# CITY OF ALBUQUERQUE

**Re: Global Storage, 12000 Candelaria Blvd. NE,  
(H-22/D073)  
Approval of Permanent Certificate of Occupancy,  
Engineer's Stamp Date 4/26/2005  
Certification dated: 09-21-07**

**Re: Global Storage Self Storage Building, 2620 San Mateo Boulevard  
Grading & Drainage Plan - Engineer's Stamp dated 4-26-05 (H22-D73)**

GRADING AND DRAINAGE PLAN

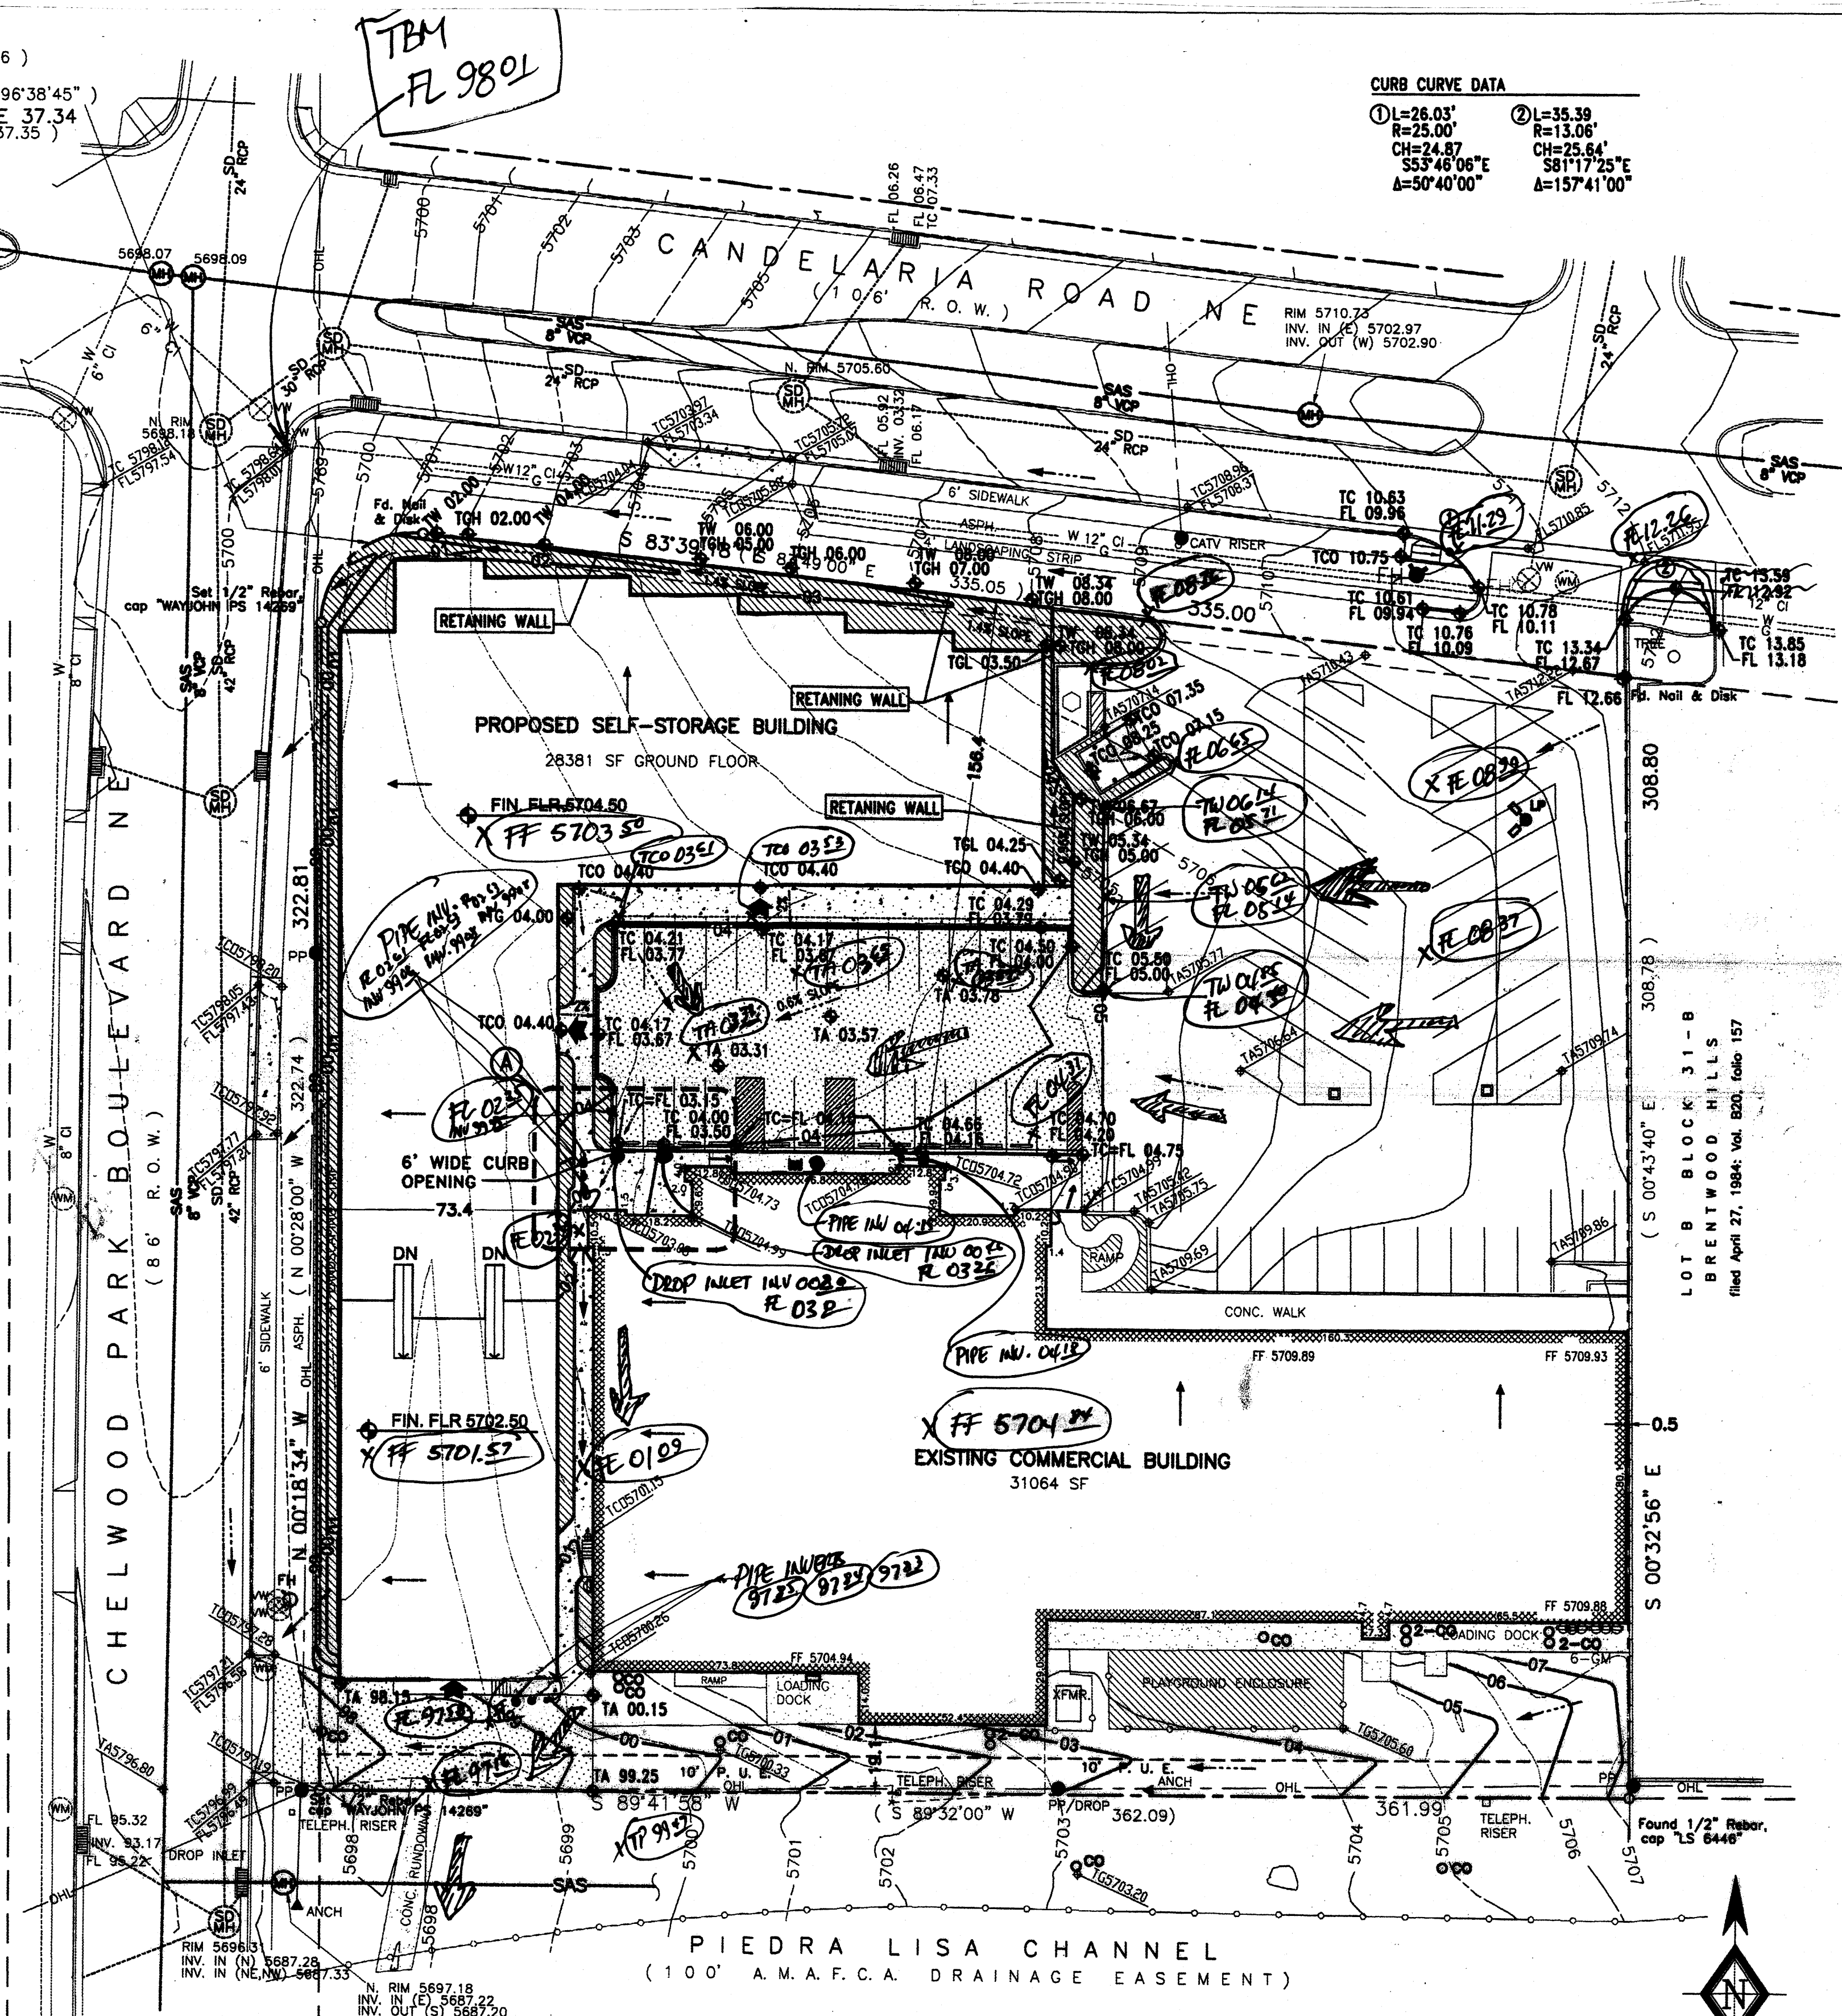
Based upon the information provided in your submittal dated 4-27-05, the above referenced plan cannot be approved for Building Permit until the following comments are addressed:

- Site needs to be graded so that the majority of the site runoff is discharged through the existing concrete rundown to the Piedra Lisa Channel.
- The City does not allow storm runoff from commercial property to flow across the public sidewalk. Roof runoff from the proposed self-storage building needs to be conveyed through a roof drain system and directed to the existing concrete rundown.
- The runoff that is directed along the sidewalk between the existing building and proposed building needs to be conveyed in a channel or storm drain system.
